16/01563/F Muddle Barn Farm, Colony Road, Sibford Gower

Application No: 16/01563/F

Demolition of an existing dwelling and a range of large scale equestrian buildings and the erection of a replacement dwelling including associated works and landscaping (resubmission 15/01693/F)

Datum 165.00m  
NORTH ELEVATION

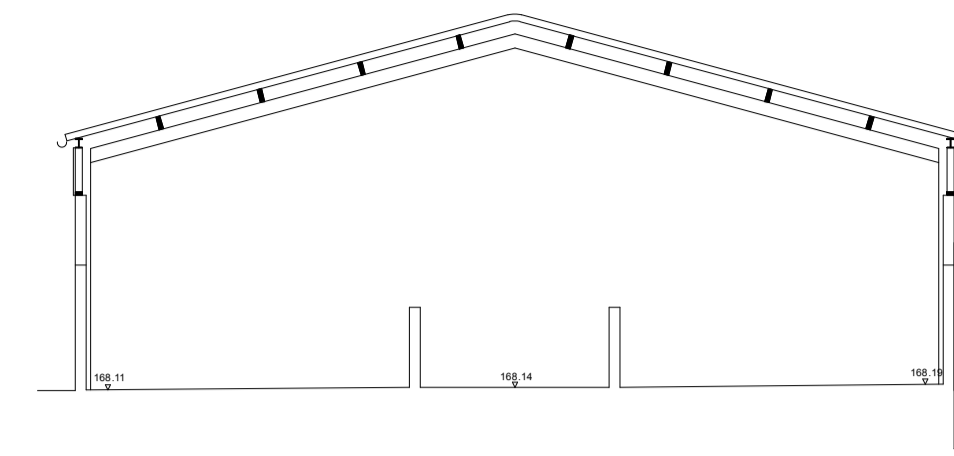
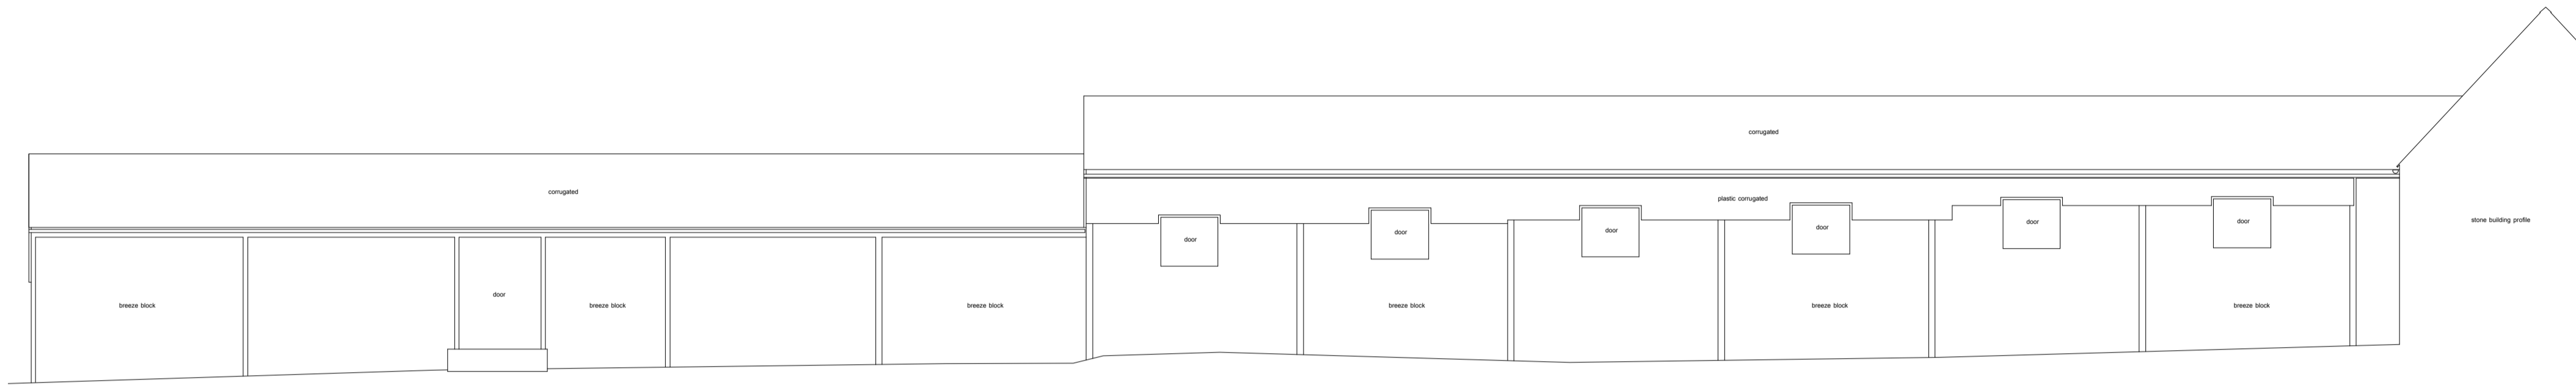
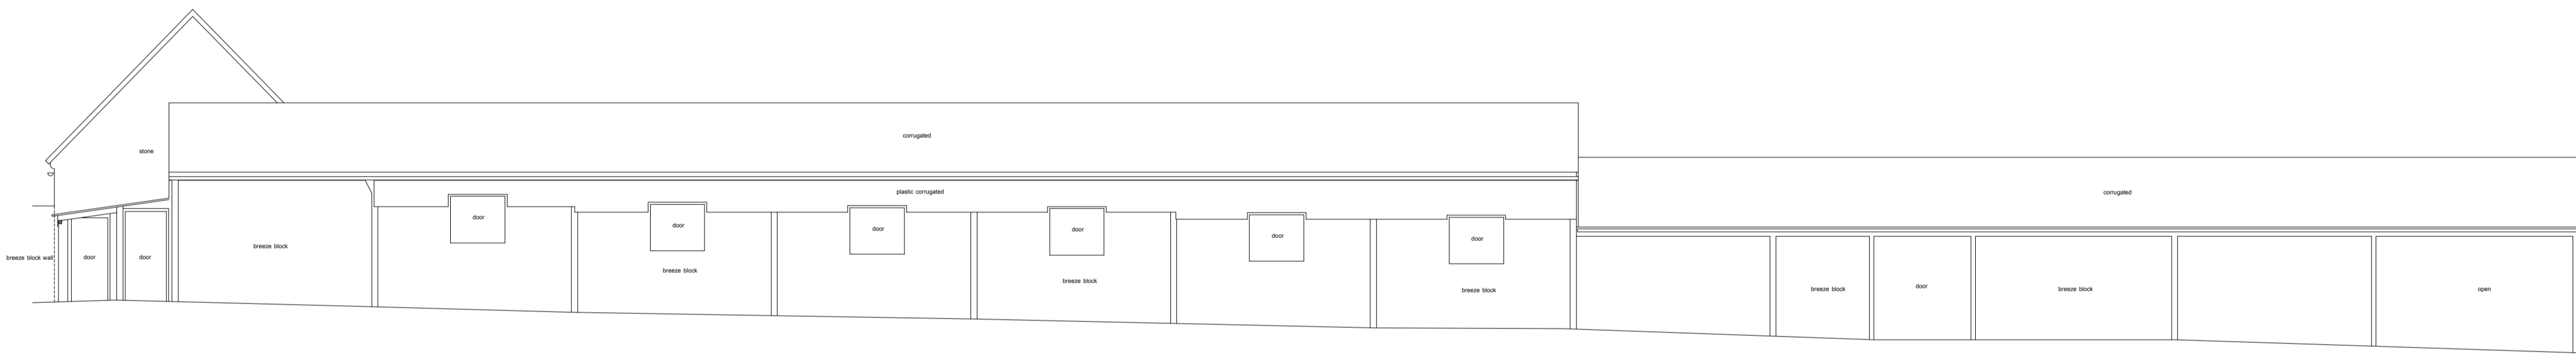
North elevation: It is a pity that all the accommodation cannot be contained within the main house. The addition of the kitchen extension, with its own extension for the utility/plant room do not enhance the design of the main house and are not yet fully resolved. The Architect was going to look at this following our meeting. Externally it would look better if the kitchen extension moved forward, this would avoid the awkward rainwater arrangement but would mean the kitchen would be entered on the corner. As proposed we have the awkward rainwater hopper arrangement to the valley and the door opens just off centre which would always look odd. By moving the kitchen forward to the west you would lose the thin window to the dining room but it would help the rainwater disposal and avoid the offset door under the ridge of the kitchen ceiling when looking towards the main house internally.

The detail of the rainwater goods/sump from valley gutter needs to be neatly handled and should be conditioned to arrive at a more elegant arrangement (see comment above).

Query how the rainwater disposal of flat roof below the ridge will be handled?

The presumed en-suite on gable wall at first floor won't have a window.

Dormers look too tall, and corresponding proportion of glass – recommend these are reduced in height so the ridge of the dormer does not project above the ridge of the linking roof between the two main roofs and the proportion of the glass is also shorter than currently shown in the dormer casements.

Glazed screen to kitchen to the west elevation the top of the screen aligns with top of windows to the main house but on east elevation top of window is lower. Consider it would look more subservient if the screen was also lower than the top of the windows.

The ridge of the utility/plant room wing needs to come in below the ridge of the kitchen extension, it looks a bit tight as drawn.

Query the treatment of the double doors on the utility/plant room wing are these louvred? If so the traditional game hanging larder structures might provide inspiration for ventilation. Details to be conditioned.

Detail 3 - Head & Frame detail

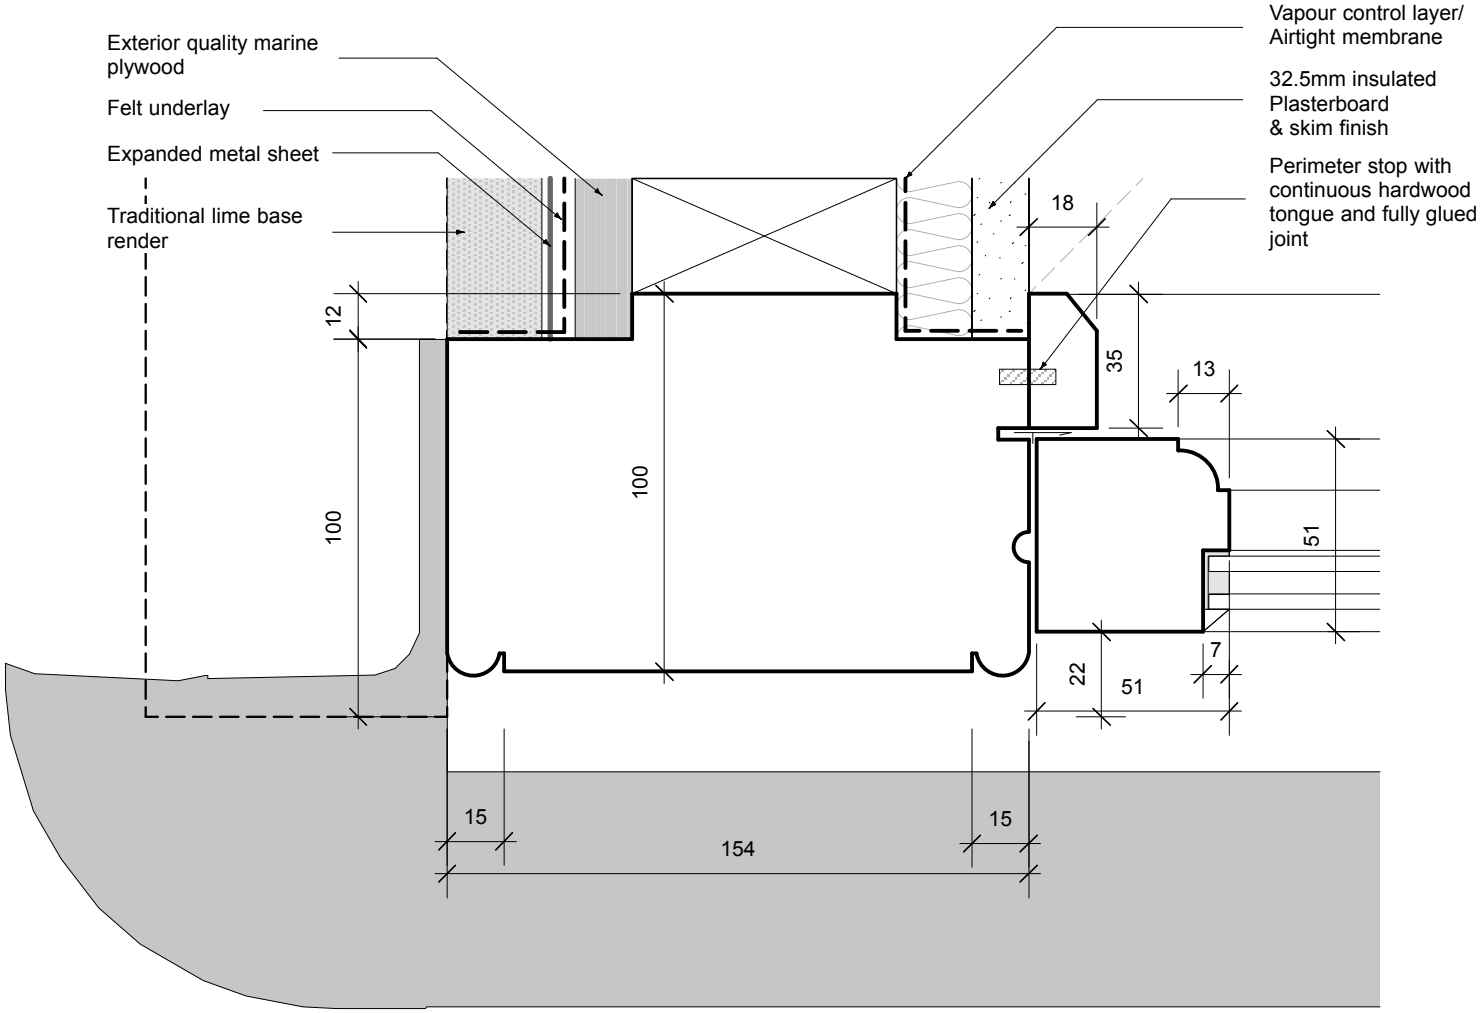
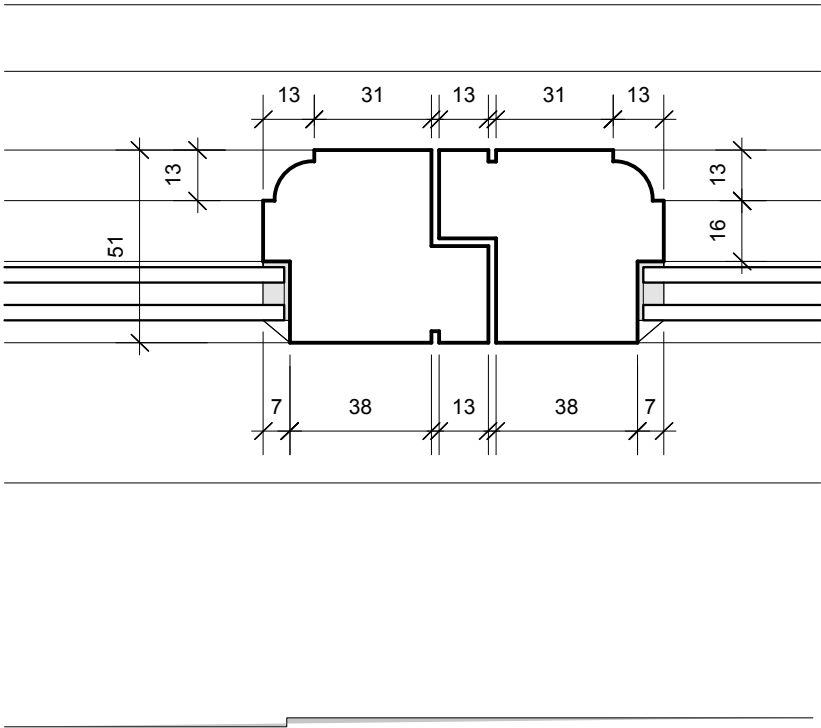
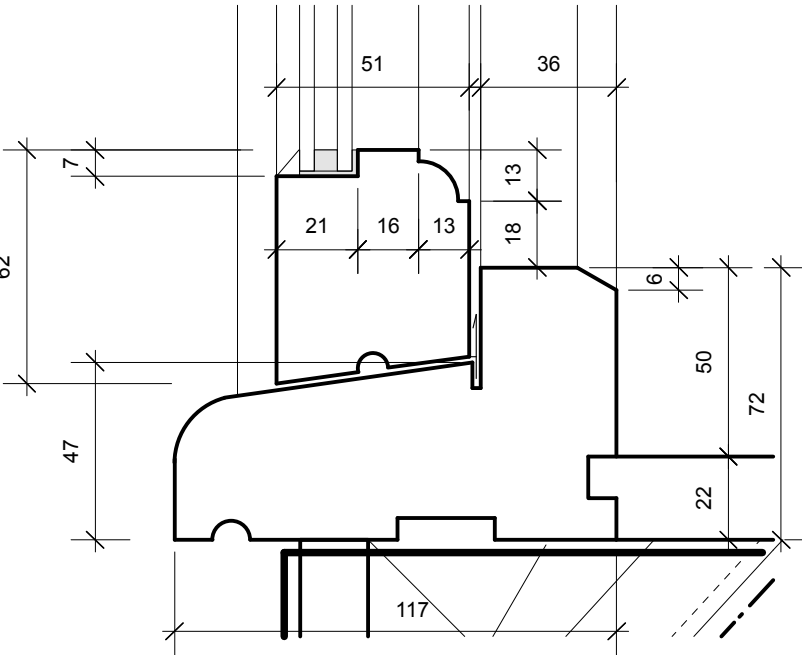
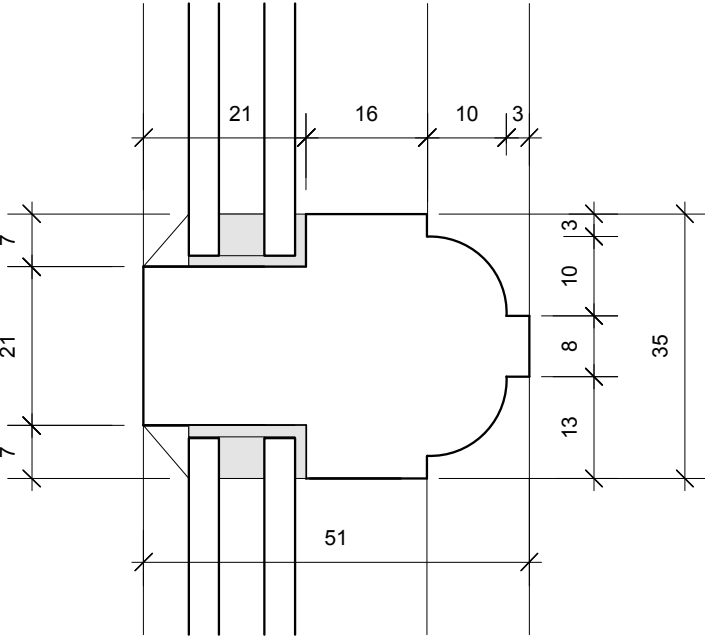
- Timber sliding sash and case windows and colour:
Detail submitted shows sash box hidden in stone reveal (typical detail after 1774 in London by law, later copied in other parts of the country) with glazing bars at 35mm wide (typical 38mm in late 17thC/ early 18thC but by late 18thC the glazing bars had slimmed down), Historic England '<https://content.historicengland.org.uk/images-books/publications/traditional-windows-care-repair-upgrading/heag039-traditional-windows.pdf/>' + need to think about avoiding cold bridging and draftstripping in due course. Historic England illustrate slimline double glazing with an 18mm glazing bar. The colour of the spacer bar/edge between the two sheets of glass needs to have a non-metallic finish – matt black might work better with certain colours, especially if an off white or colour is proposed suggest trialing which colour looks best with chosen window colour.
